Rezoning Transportation Analysis
Petition Number: Insert Zoning Petition #2021-257
General Location Identifier: 11306113

Revision Log:	Date	Description
	04-18-2022	First Review (KP)
	05-24-2022	Second Review (KP)

Transportation Summary

Conceptual Site Plan

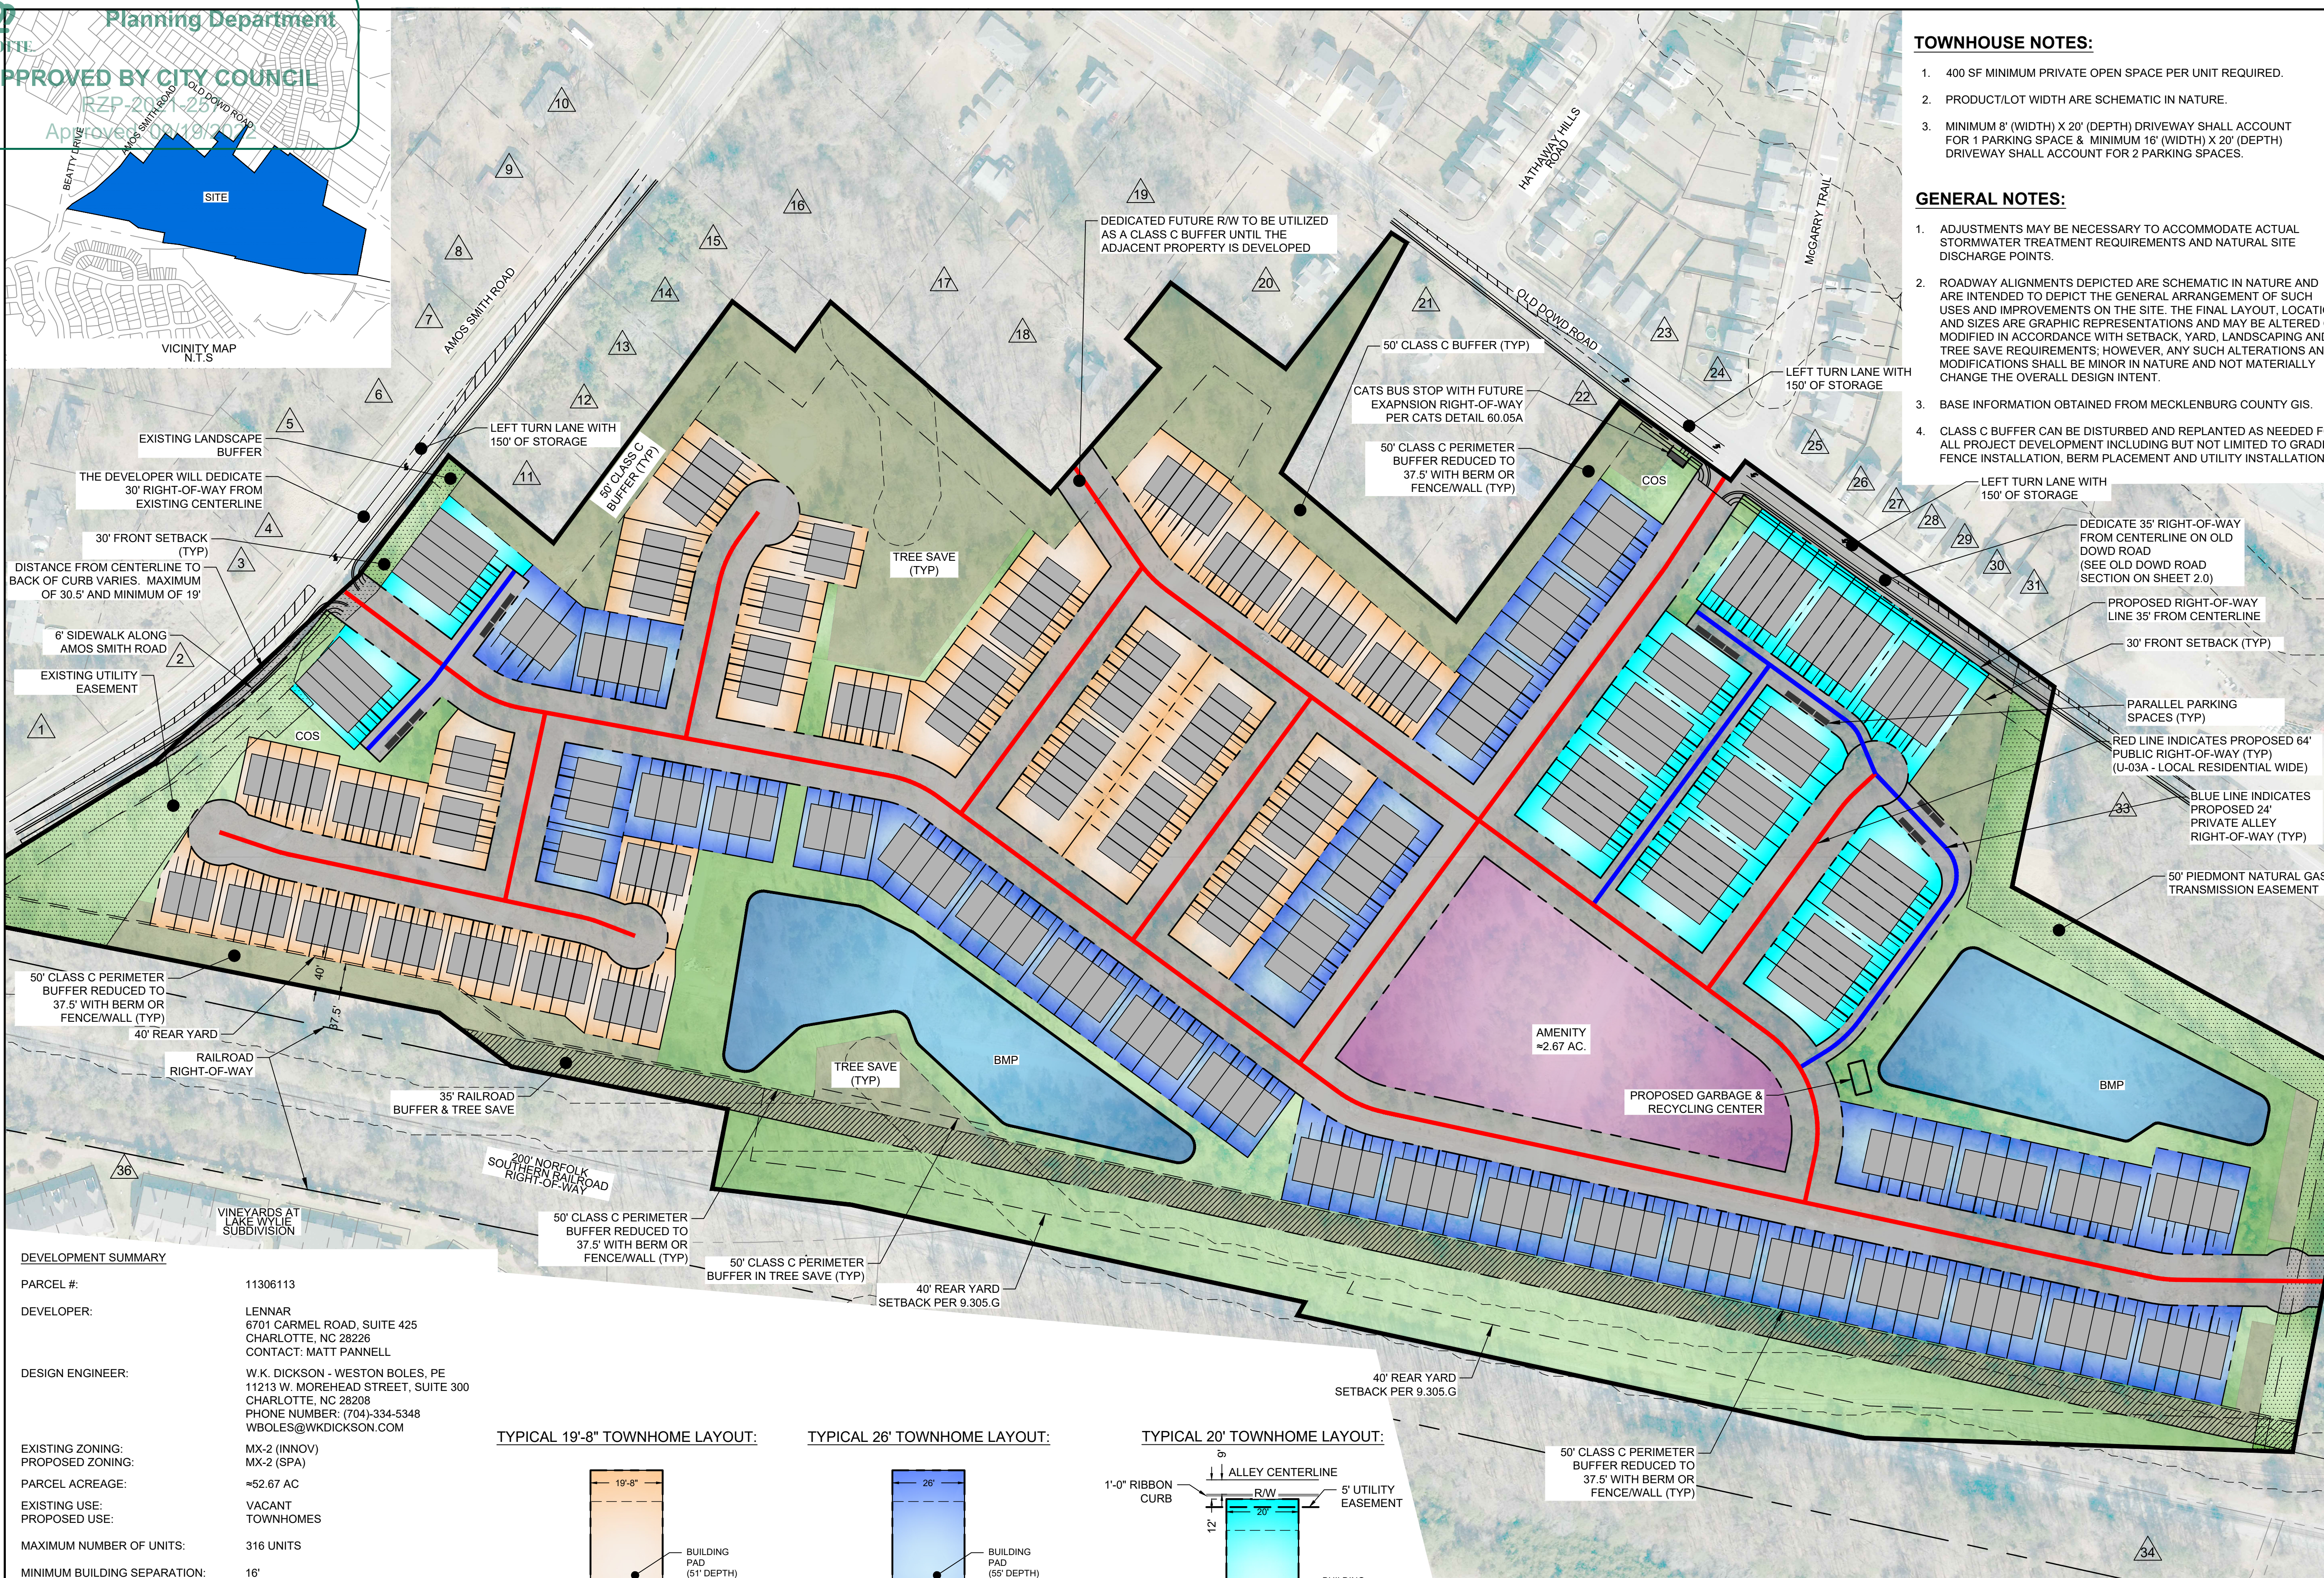
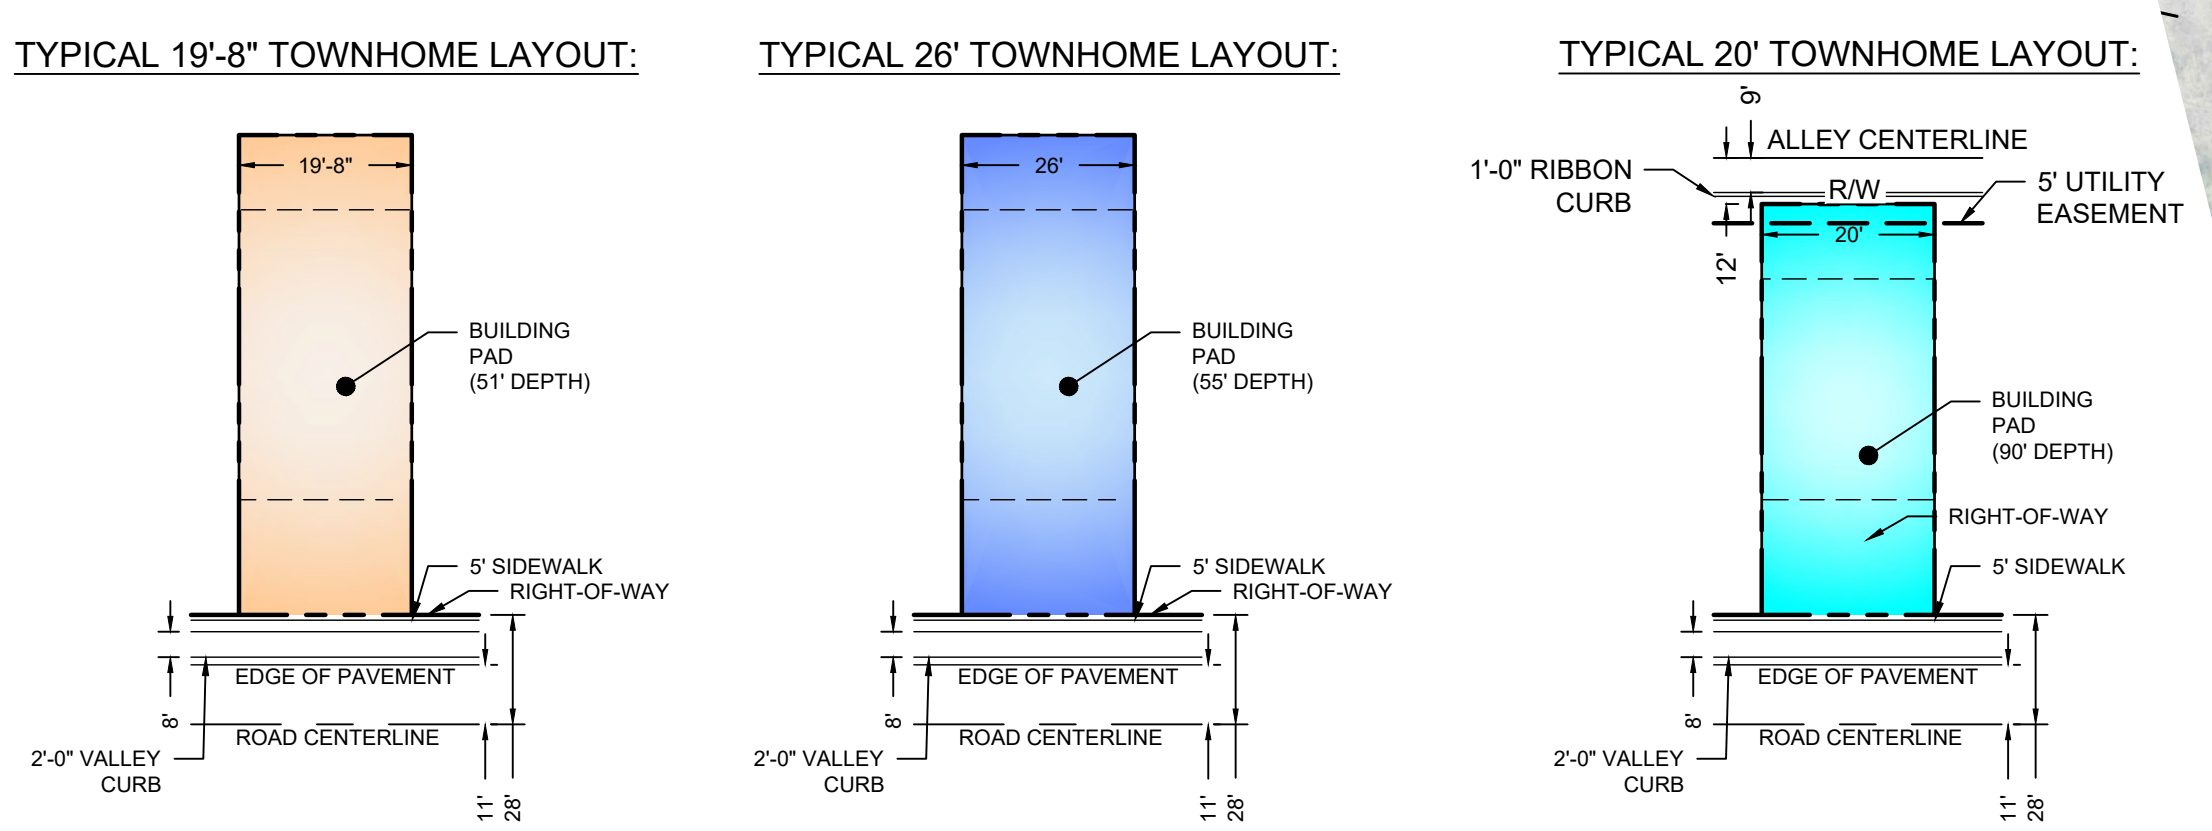
- a. ~~Amos Smith Road:~~ Label and dimension the existing back of curb from the existing road centerline.
- b. ~~Old Dowd Road:~~ Revise the site plan and conditional notes to commit to construct the curb line measured from 27 feet from the existing road centerline to the back of curb.

Revise the site plan and conditional notes by incorporating the suggested roadway improvements from the approved TIS.

- a. ~~Amos Smith Road:~~ Revise site plan by labeling and dimension the right of way from the existing road centerline.
- b. ~~Old Dowd Road:~~ Revise the site plan and conditional note(s) to commit to dedicate 35 feet of right of way from the existing road centerline.

- 8. A site plan note specifying that all transportation improvements will be approved and constructed before the site's first building certificate of occupancy is issued as needed. The petitioner may phase transportation improvements if said improvements and phasing are explicitly described in site plan notes.
Update to Comment from 05-18-2022 Site Plan: Confirm with NCDOT that tying the roadway improvements to 100th certificate of occupancy is Acceptable.

- 9. Revise the site plan and conditional notes to commit to provide a street stub, in accordance with CLDSM standards, to the northwest property boundary.

Outstanding Comment from 04-18-2022: Revise the site plan to provide a street stub rather than a cul-de-sac.

- 10. Revise the site plan and conditional notes to commit extend the proposed street and provide a street stub with a temporary turnaround, in accordance with CLDSM standards, at the southeast property boundary.

Outstanding Comment from 04-18-2022: Revise the site plan to provide a street stub rather than a cul-de-sac.
